PINS Reference: EN0110021

**INFRASTRUCTURE PLANNING (ENVIRONMENTAL IMPACT ASSESSMENT)**  
**REGULATIONS, 2017: HEDGEHOG GROVE SOLAR FARM SCOPING REPORT**

This document sets out the response of Babergh Mid Suffolk District Council (BDC) to the Scoping Report submitted on 23<sup>rd</sup> April 2025 by Hedgehog Grove Solar Farm Limited in respect of the proposed Hedgehog Grove Solar Farm NSIP.

Figure 12.1
Landscape and Visual Study Area
Scoping Report
Hedgehog Grove Solar Farm

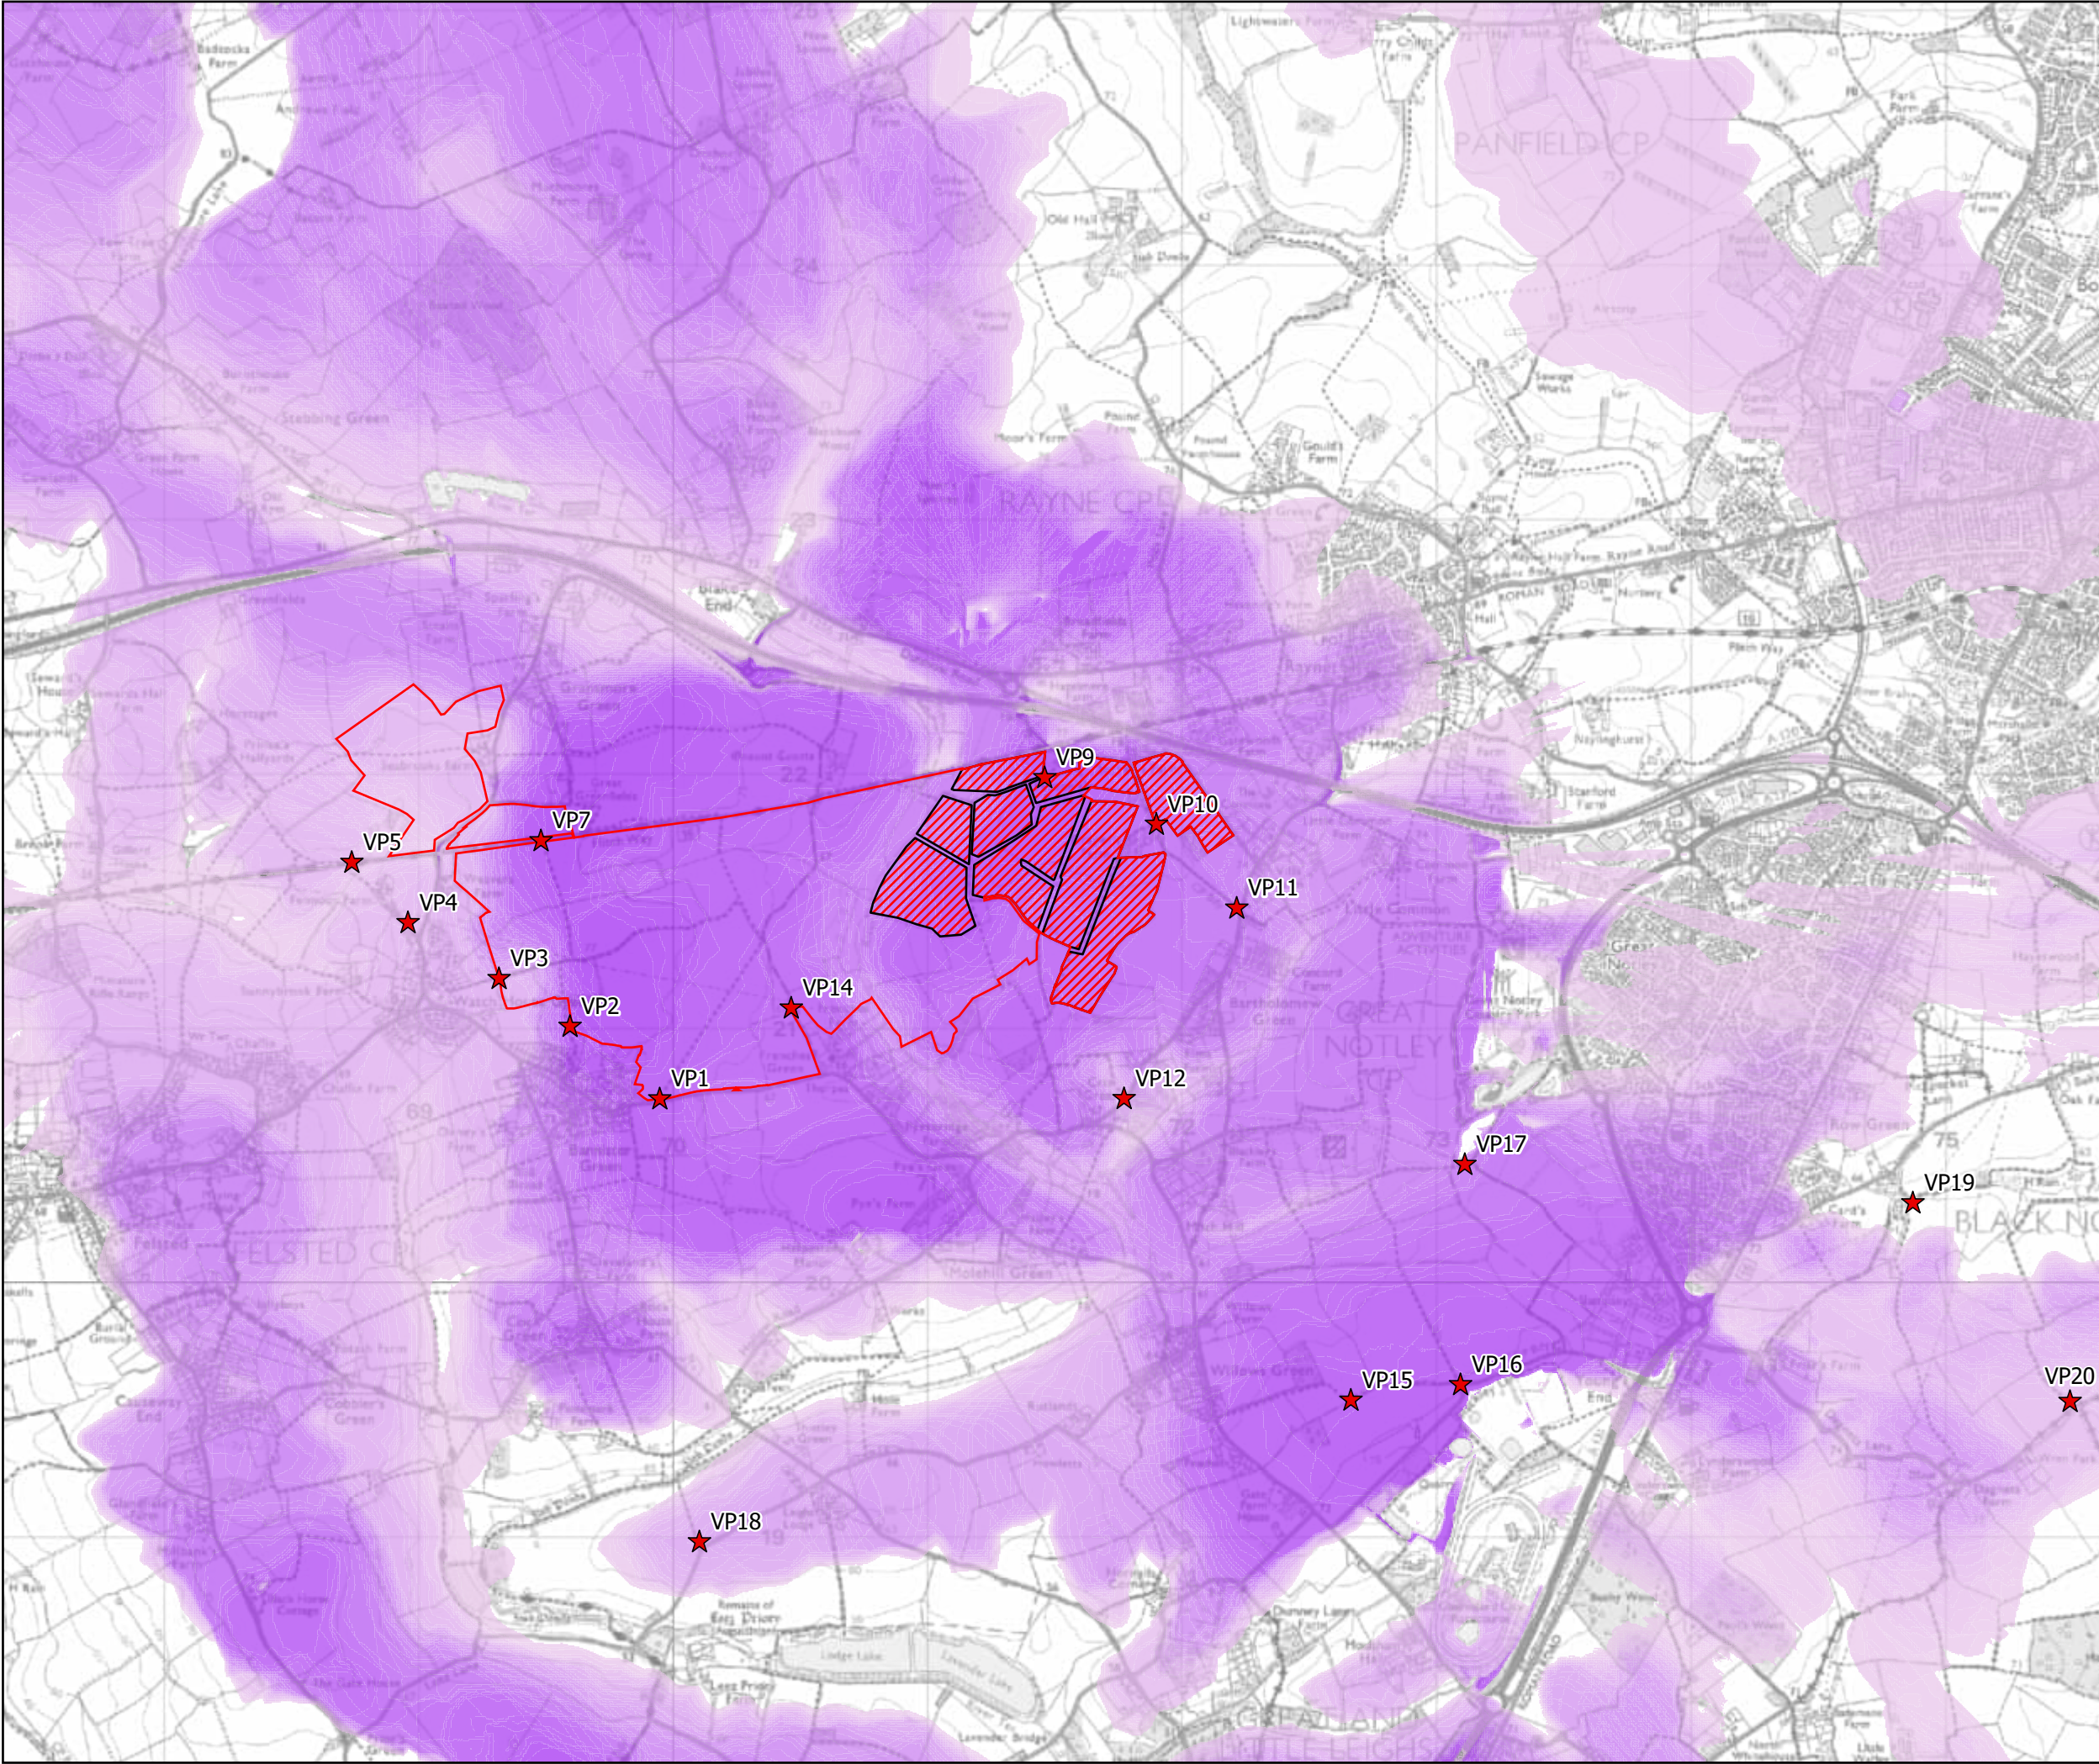
Section 12 suggests that the proposed development will likely be most visible within the immediate surrounding of the site. However, BDC request that the LVIA takes into account any potential visibility of the proposal from Babergh District, primarily from any National Landscapes, Conservation Areas or Project Areas.

Figure 14.1
Socio-economic and Land Use Study Area
Scoping Report
Hedgehog Grove Solar Farm

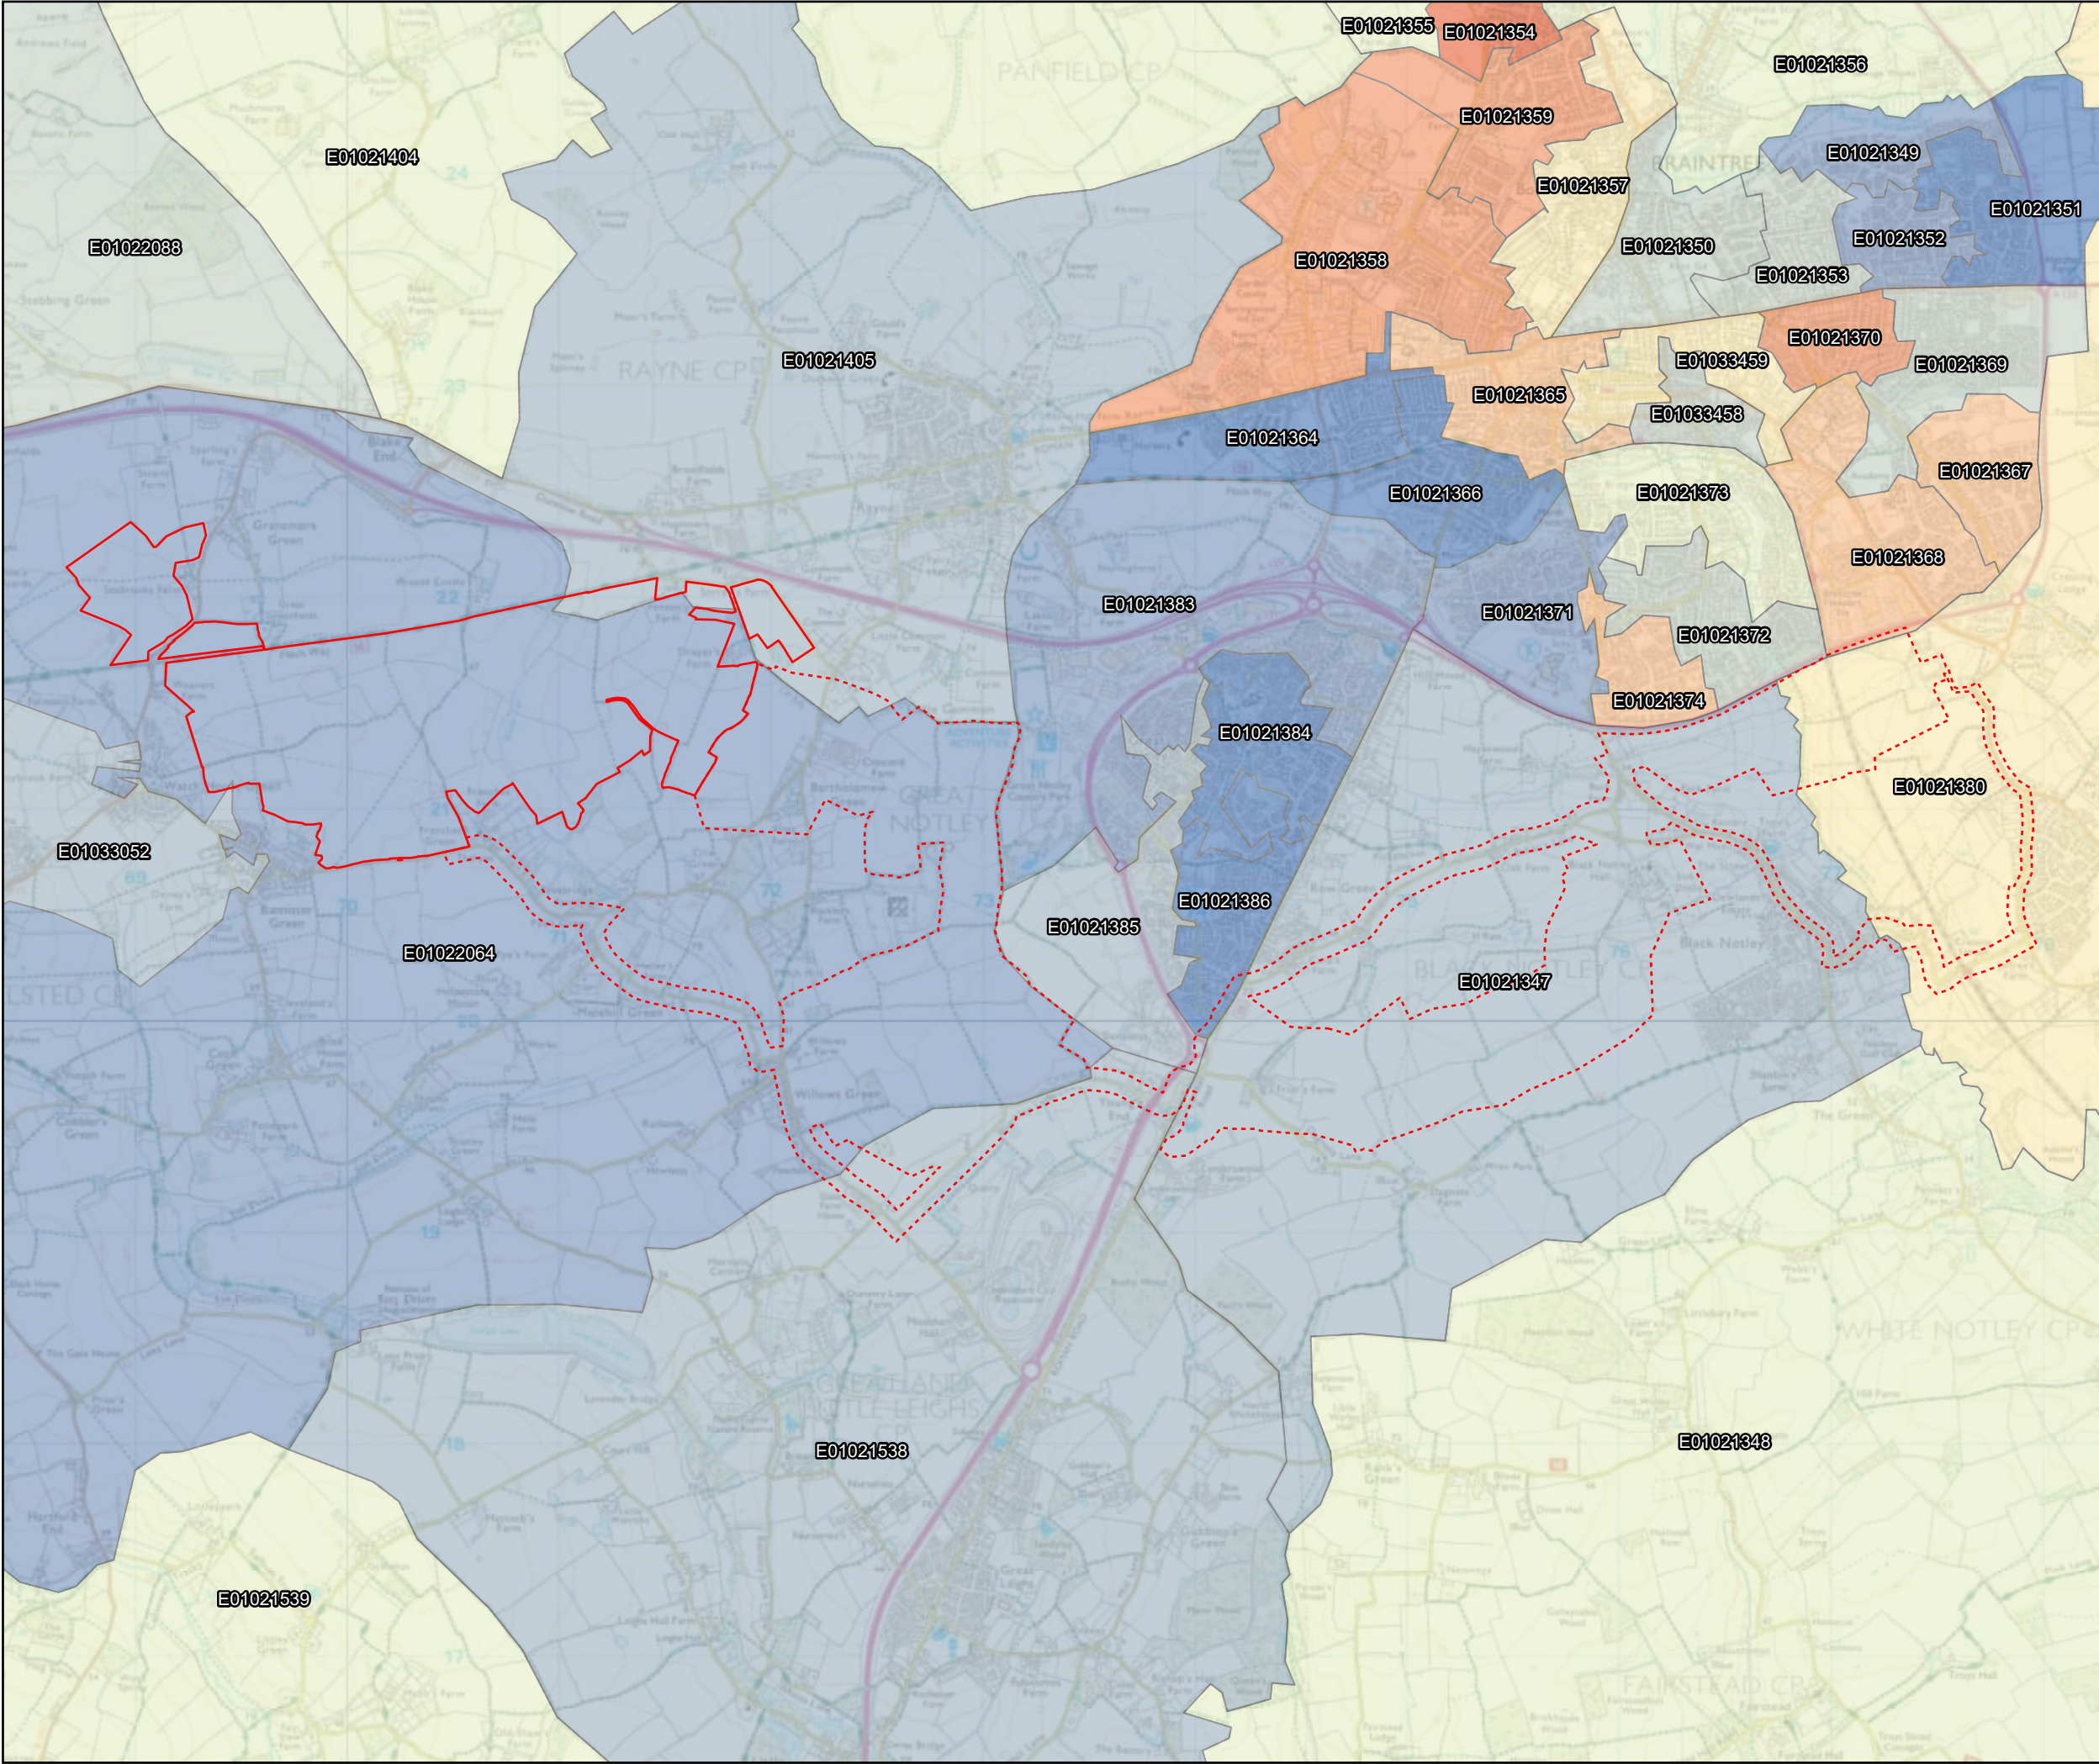
BDC acknowledges that the primary socio-economic and land use impacts will be on the local authority areas of Uttlesford District Council and Braintree District Council.

However, BDC are concerned at the lack of assessment of impacts on the economy of the wider region, especially having regard to the reliance of the tourism industry on a relatively limited highway network and also the cumulative impacts of the delivery of a number of projects in the area within a similar timeframe on workforce sourcing, accommodation and social integration and the highway network.

Figure 15.1
Indicative Traffic and Transport Study Area
and Sensitive Receptors
Scoping Report
Hedgehog Grove Solar Farm

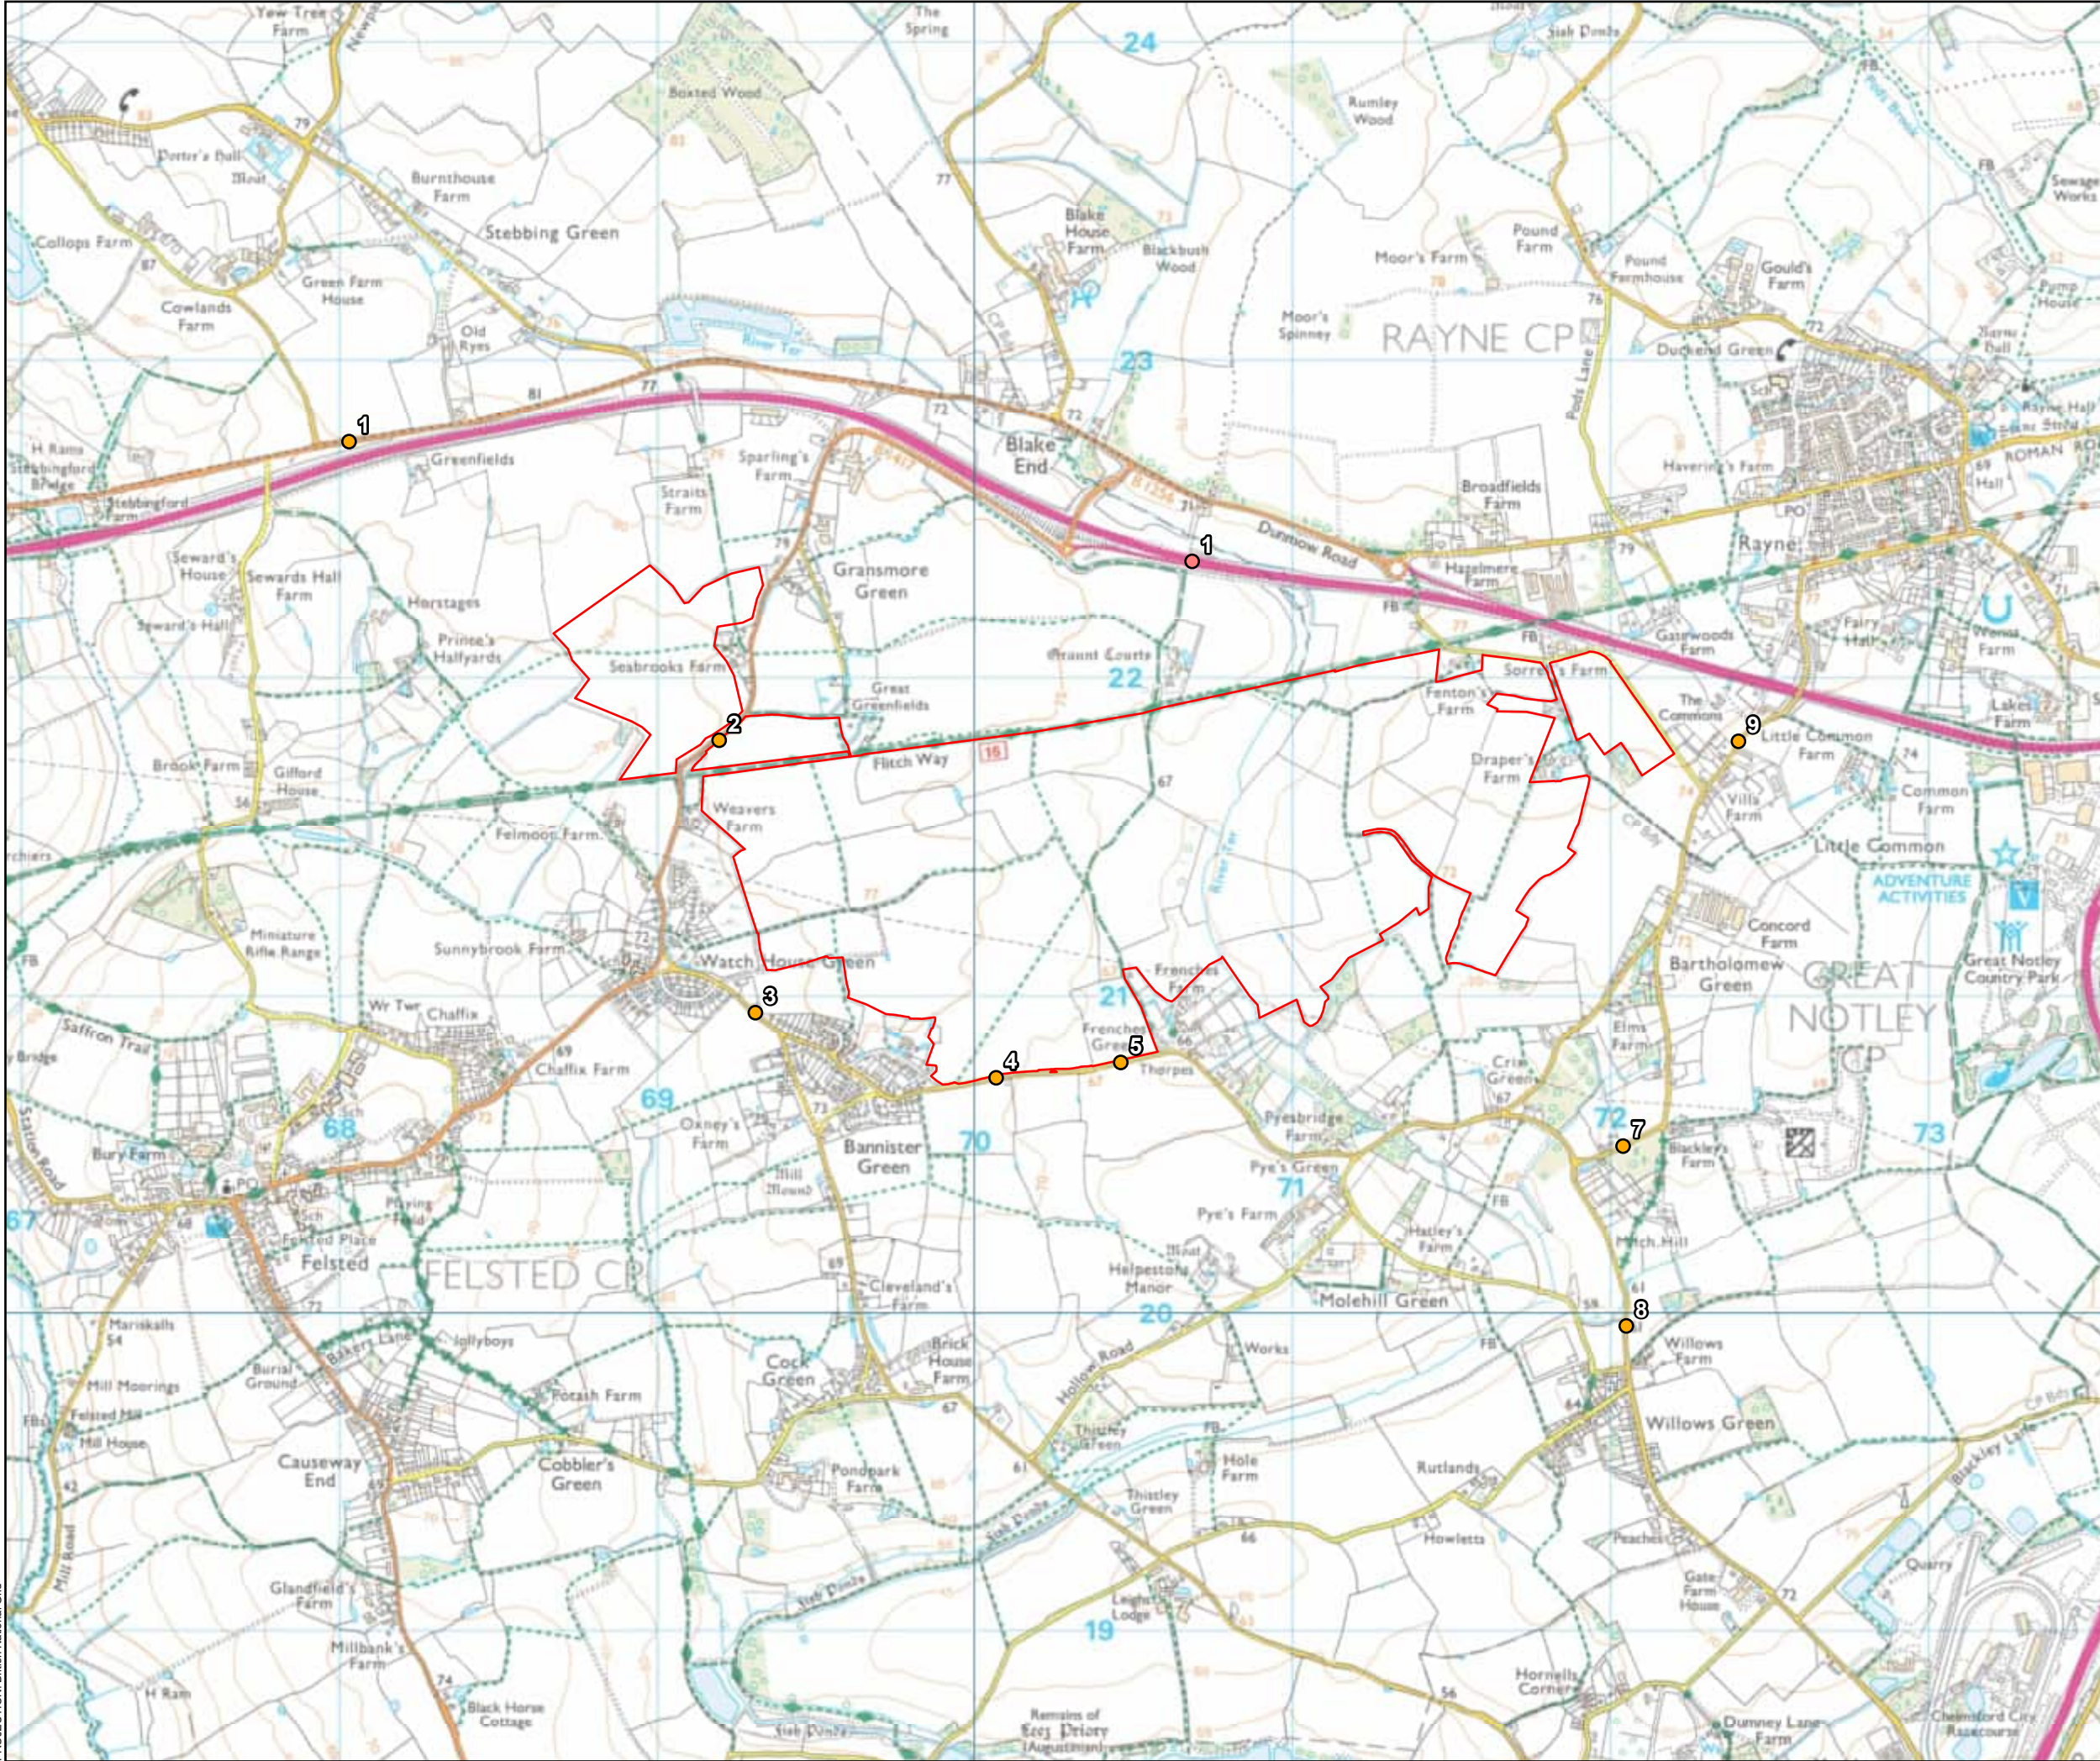
Whilst it is acknowledged that the main impact on traffic and transport will be within the immediate proximity of the proposed site, BDC would like to see the assessment broadened to include the A131 and A12 highways which are known to be susceptible to congestion and incidents.
